**KIRKLEES METROPOLITAN COUNCIL
INVESTMENT & REGENERATION SERVICE**

DELEGATED DECISION TO DETERMINE PLANNING APPLICATIONS

Reference No:	2023/62/91410/W
Site Address:	10, Mallard Way, Slaithwaite, Huddersfield, HD7 5JL
Description:	Erection of two storey side extension (within a Conservation Area)
Recommending Officer:	Sam Jackman

DECISION – REFUSED

west elevation

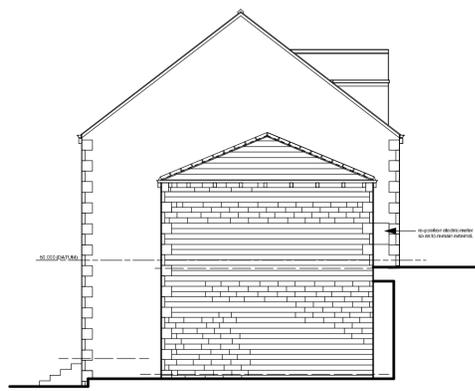
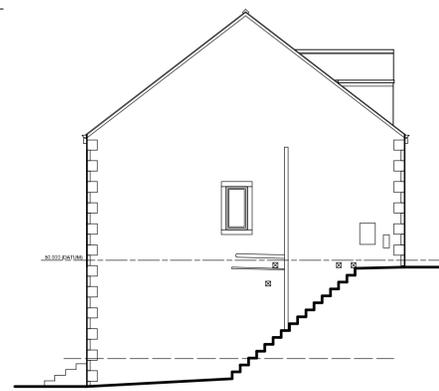
The property to the west is both set lower and forward of the host property, as well as being over two levels, unlike the host property being over three floors. Therefore, given the topography of the area and the proposal being a two-storey side extension, the proposal is overbearing to a degree, in relation to this property. With regard to overshadowing the extension would be kept within the front and rear elevations of the host property, however, would be

built almost on the shared boundary therefore, reducing the gap between the two properties. Therefore, given the orientation of the two properties and the relationship between them both it is considered that the extension would have an overshadowing effect as well as being overbearing given the height and topography of the area and the mass of walling so close to the boundary.

It is accepted that the application has been amended to reduce its depth and bulk by replacing the gabled roof with a hipped roof. However, this does not overcome the concerns of the impact of the proposal by being overbearing / leading to overshadowing.

1. The proposed extension, by reason of its position, overall scale and proximity to neighbouring properties, would result in an unacceptable degree of harm to the amenities of the occupiers of the adjacent dwelling No. 12 Mallard Way in terms of being overbearing, leading to loss of light and overshadowing. The proposal therefore fails to comply with Policy LP24(c) of the Kirklees Local Plans, policies within Chapter 12 of the NPPF and Principles, 5 and 6 of the Kirklees House Extensions and Alterations Supplementary Planning Document.

upper ground floor plan

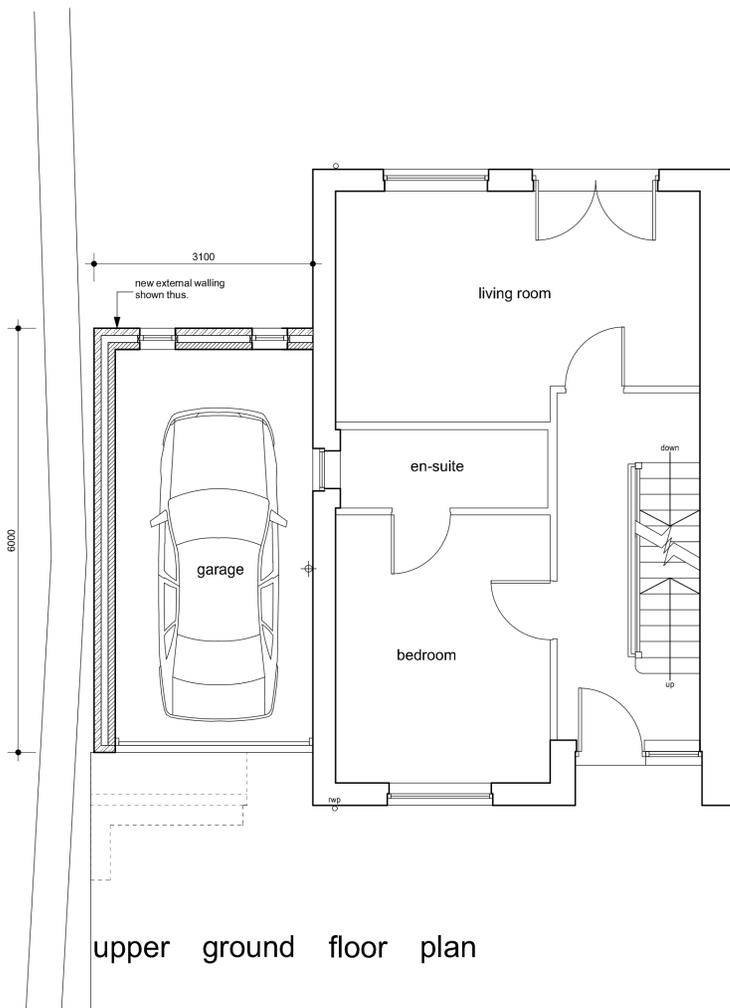
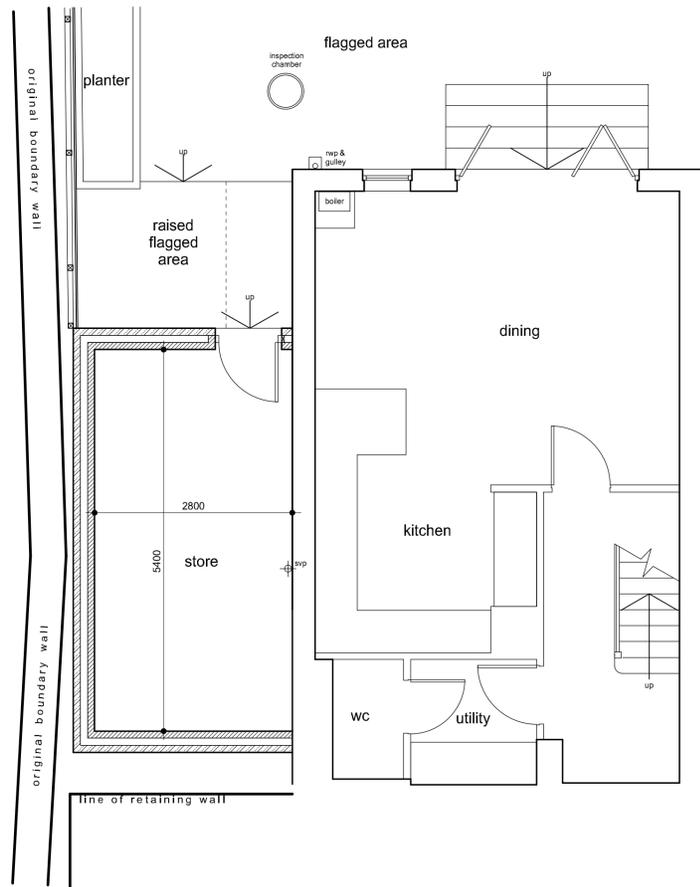
With regards the SPD for side extensions, the extension will be set back approx. 0.7m from the front elevation and wouldn't be the full depth of the property, complying in part with the SPD. However, it would be built up to the shared boundary, utilising all the space to the side, therefore, wouldn't retain a 1m gap to the boundary.

However, the reserved matters application shows that the area to be used as access into the new garage is for the storage of bins as well as providing landscaped area in the form of raised beds, which haven't been installed and albeit the homeowner uses this area for storage of bins and there is limited space for these to be relocated, once the garage is built.

2. The proposed side extension given its relationship with its neighbour, reducing the separation distance between the two properties, and creating a vehicular access over an area intended for soft landscaping would have a harmful impact on the visual amenity of the area, street scene and Slaithwaite Conservation Area. The proposal therefore fails to comply with Policies LP24 (a & b) & LP35 (3a & b) of the Kirklees Local Plan, principles 1, 2, 7 and 9 of the Supplementary Planning Document on House Extensions (SPD) and policies within Chapters 12 & 16 of the National Planning Policy Framework.
